Subject: Fwd: Some observations on the use of managed grassland in the Brent Goose Mitigation Plan for Pagham Harbour

Subject: Some observations on the use of managed grassland in the Brent Goose Mitigation Plan for Pagham Harbour

Could you please take into account the following observations when you become involved in progressing application P/140/16/OUT (Land south of Summer Lane) with Arun District Council.

Attachment2

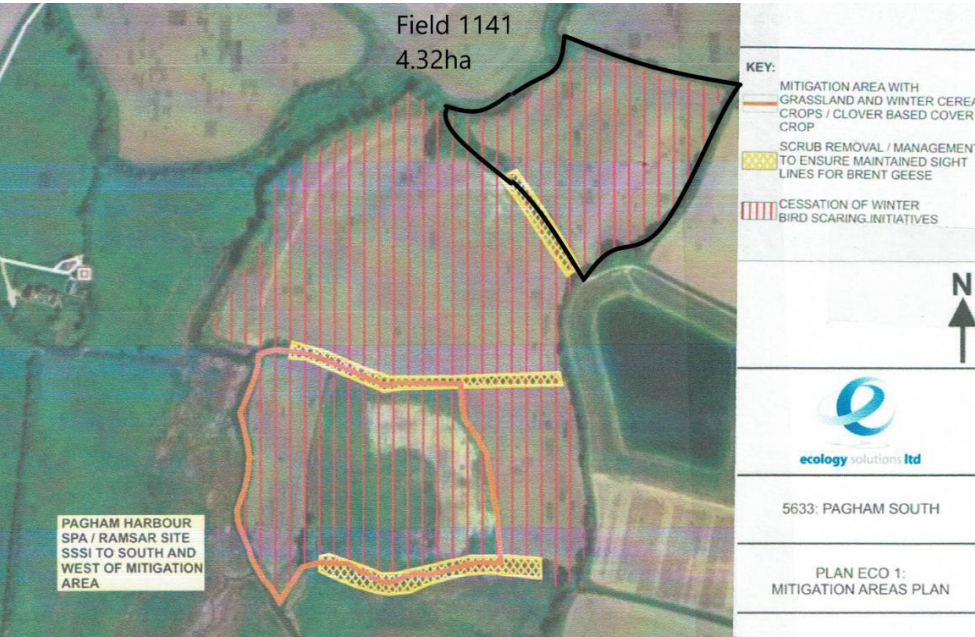
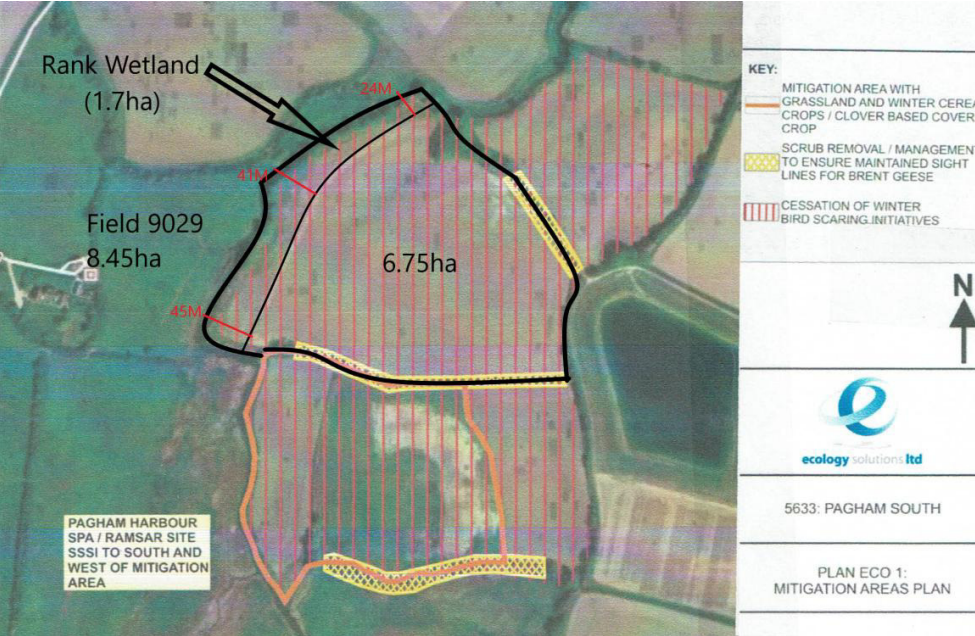
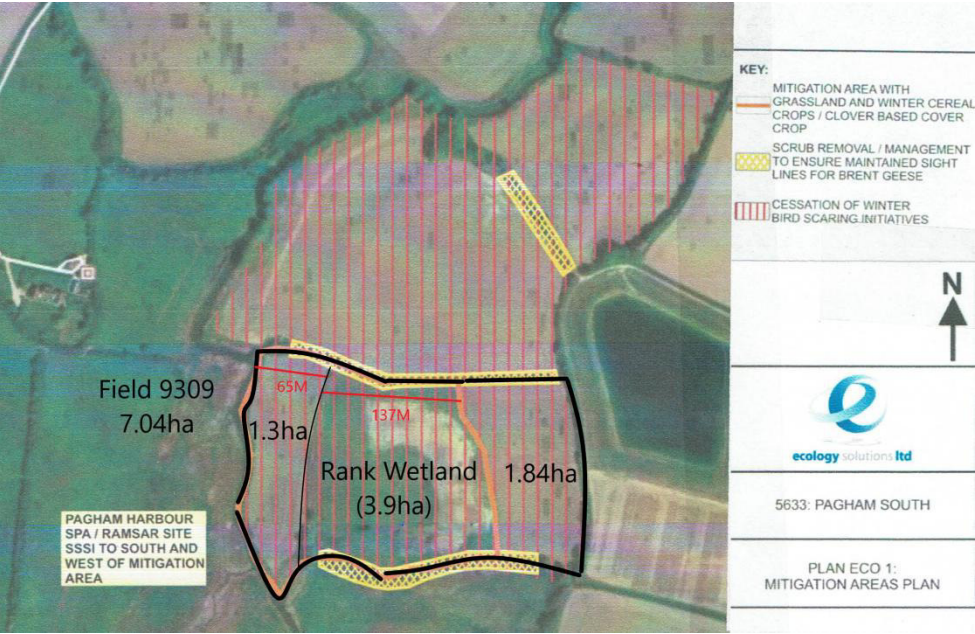
Attachment2 shows some recent cutting into the drainage ditch between fields 9029 and 1141 in, what appears to be, an attempt to carry away water. Attachment2 includes photographs in March and April 2019 of crop damage (winter wheat) in these fields. Attachment3 shows damage in January 2020 to grassland also in both these fields. Although in its present form the BGMP does not propose large areas of grassland it does make clear that any sown should include of a high proportion of ryegrass. This is understandable from the point of view of goose foraging (Vickery and Gill, 1999), however, after two weeks of being submerged this cultivar starts to die off followed by weed infiltration (Defra, 2014 section 4.2). Evidence of year-on-year crop damage in fields 9029 and 1141 would mean that the above cultivatable area total of 14.21 hectares (ha) may be overly optimistic. An estimate of the total of all the areas of water damage is 1.1ha (attachment3) bringing the actual useful goose foraging resource area of mitigation land probably closer to a total of 13.11ha, plus an unknown additional amount via proposed landscaping work in field 9309 (3.3. below).

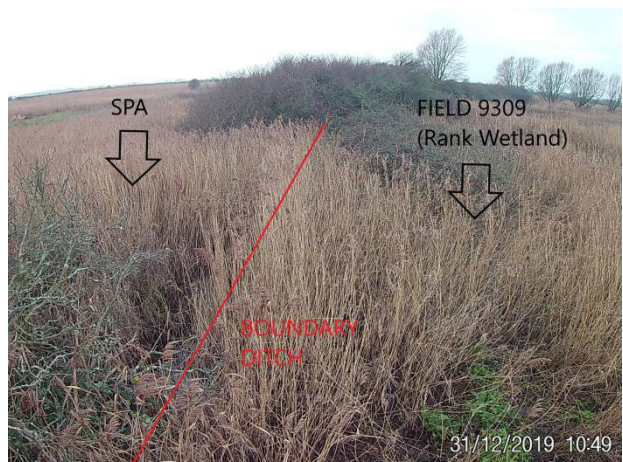
3.3. A large central proportion (3.9ha) of the southern most mitigation field 9309 is 'rank wet grassland/ruderal vegetation' (BGMP and see attachment4). The BGMP proposes that this area will be over seeded by a grassland lay and will incorporate two wetland scrapes to provide freshwater. Observing the condition of the land here (attachment4) may give some concern as to the ease of achieving this or, indeed, the necessity for the provision of water. For it to be successfully achieved would require raising some of this land clear above the water level. Brent geese are wary animals requiring a clear view of potential danger. The conflict between creating drier areas against

interrupting geese sight lines is acknowledged in the BGMP (paras 3.8 and 4.3.2) but given the examples of water depth in this rank wetland (attachment4) it is clear that some raising of soil level would be required. The BGMP states that the proposed excavated scrapes of total 0.4ha will provide material for the creation of areas less susceptible to water inundation. Considering 0.4ha is just 10% of this rank wetland area it may be wise to consider additional ways of raising the level of this land in order to make some of it suitable for grassland. Without this work, over-sowing with any seed mix, in particular one rich in ryegrass (BGMP 3.8.), could be of very limited success. An effort to open sight lines would also require regular rush and reed management. The use and storage of low ground-pressure machinery may need to be considered in the land management plan. This would be especially useful for work near the deep and concealed water course present within this rank wetland, close to and parallel with its western boundary (attachment4).
